**WALBERTON PARISH COUNCIL
INCLUDING FONTWELL AND BINSTED**

Re: Planning application WA/22/22/DOC, Global Technologies Racing Ltd, Arundel Road, Fontwell BN18 0SB.

Walberton Parish Council wishes to register an **objection** to the above planning application.

2.1.1 Floor plan

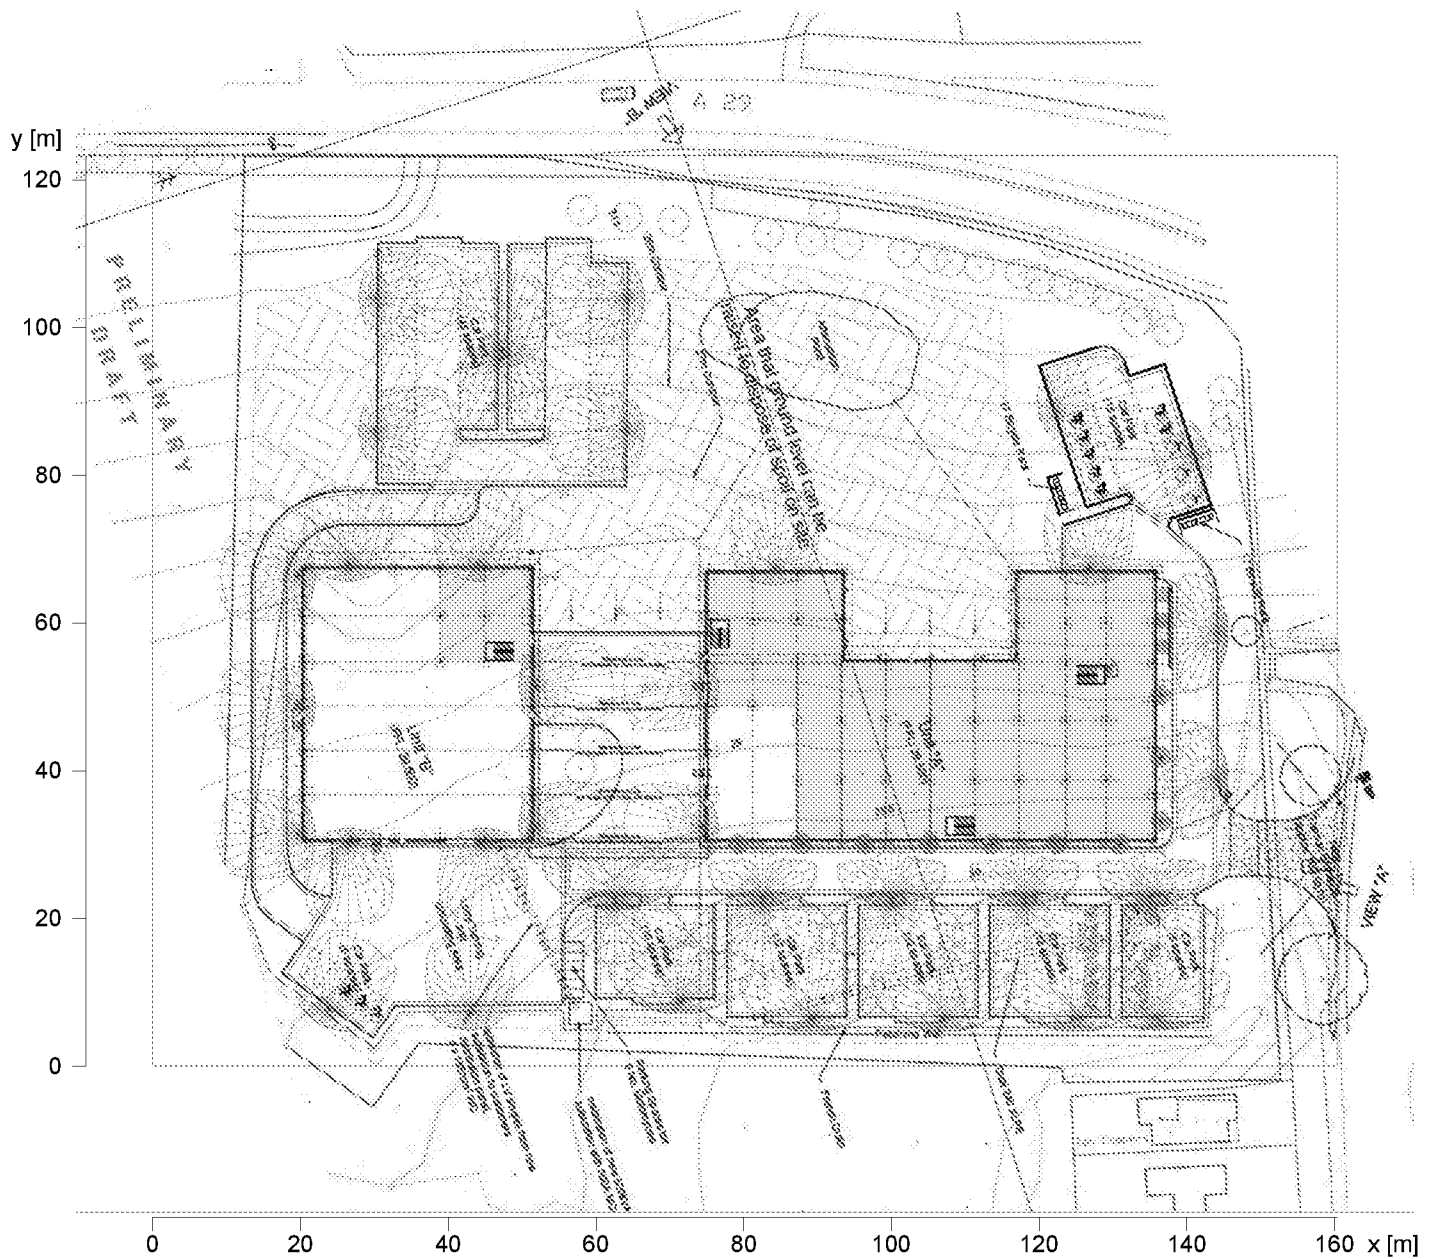
The lighting information provided is also lacking.

- The detail of the drawings is not legible
- There is no description of the number of lights, their location, their timing (ie all night or only certain periods of time) and their control (switched, permanent, motion sensor, etc)
- Information to determine compliance with Barnham and Eastergate Neighbourhood Plan policy ES16 (Dark Skies) is not present.

Drainage Layout

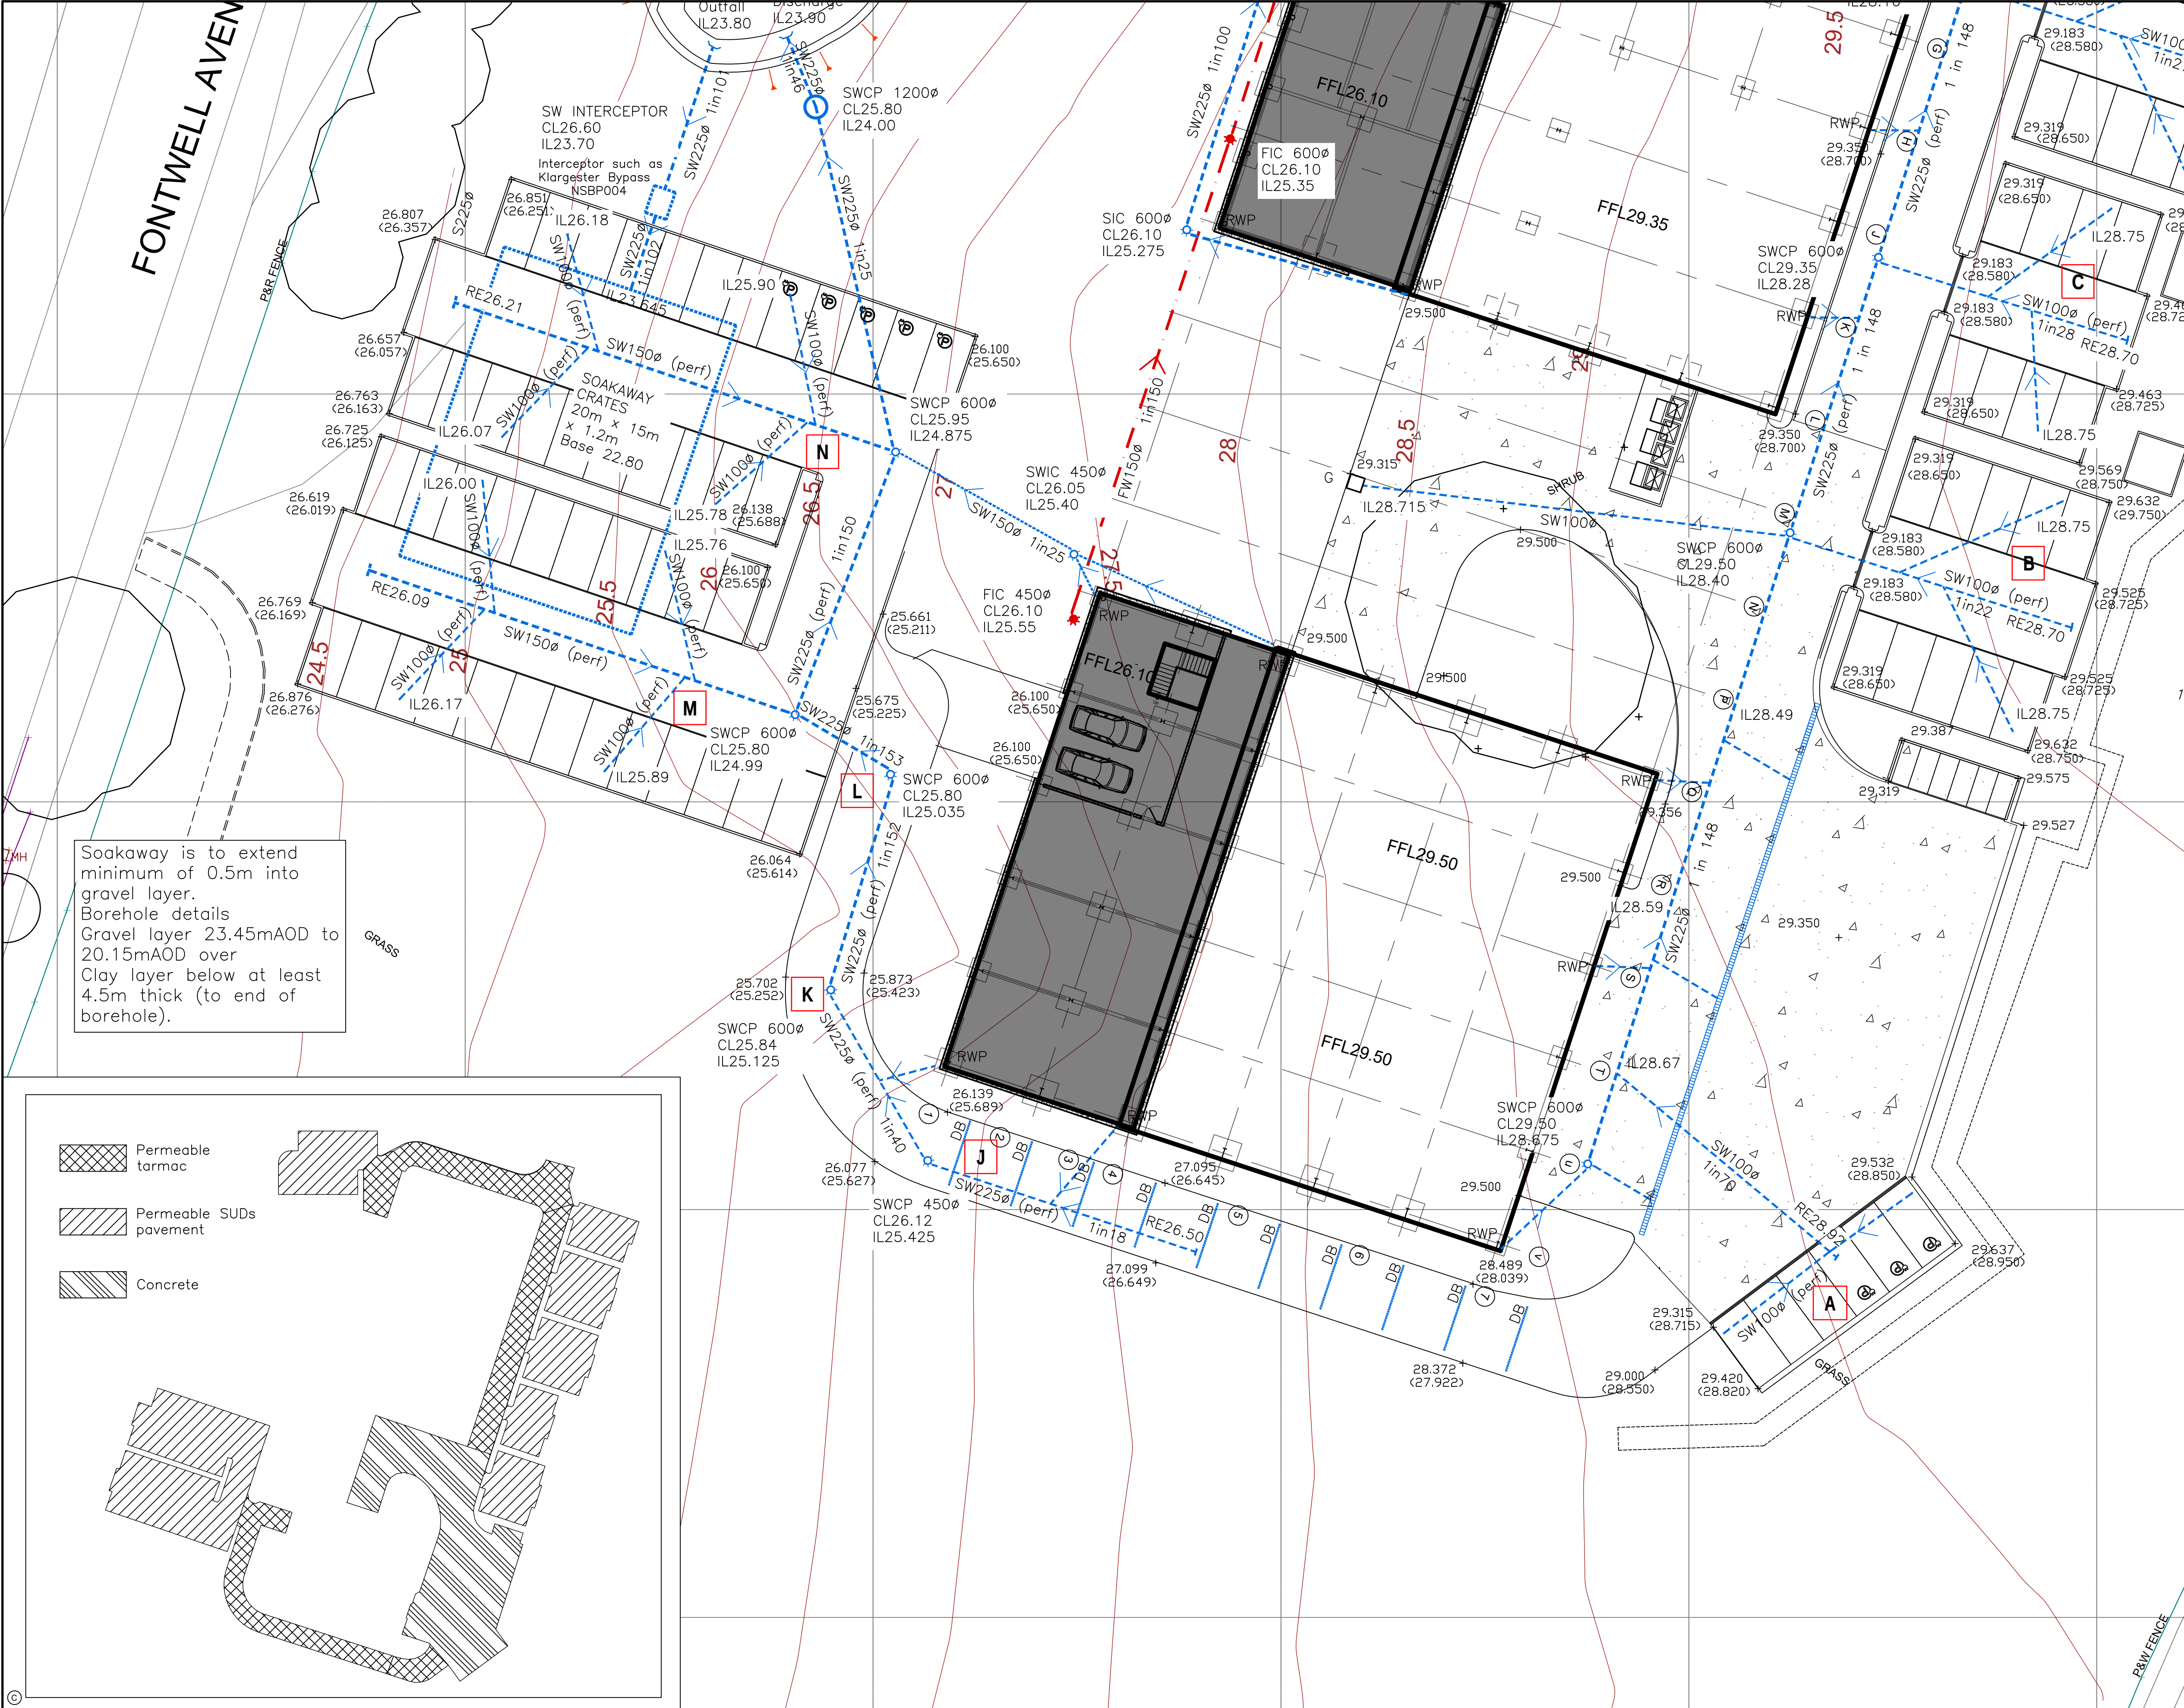
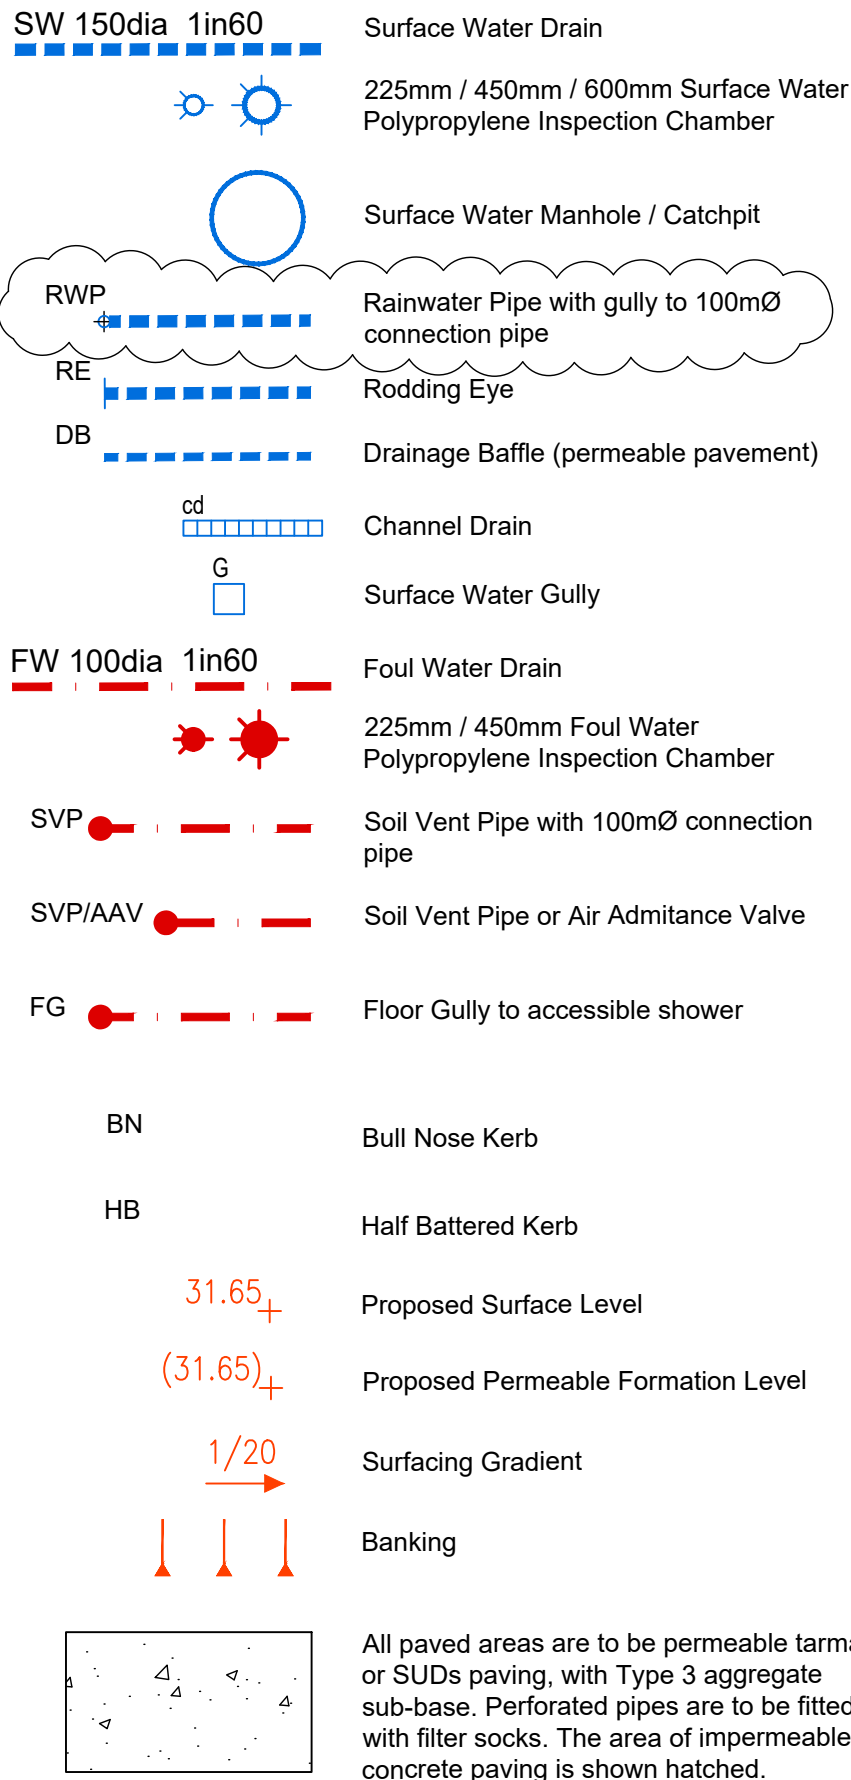
Regarding drainage, we note the engineer's comments regarding lack of clarity of information and features of the given design which are not likely to work. The preapplication advice from ADC clearly stated the extent of information required. As such, we must object as inadequate drainage will increase the risk of flooding to the neighbouring housing estate.
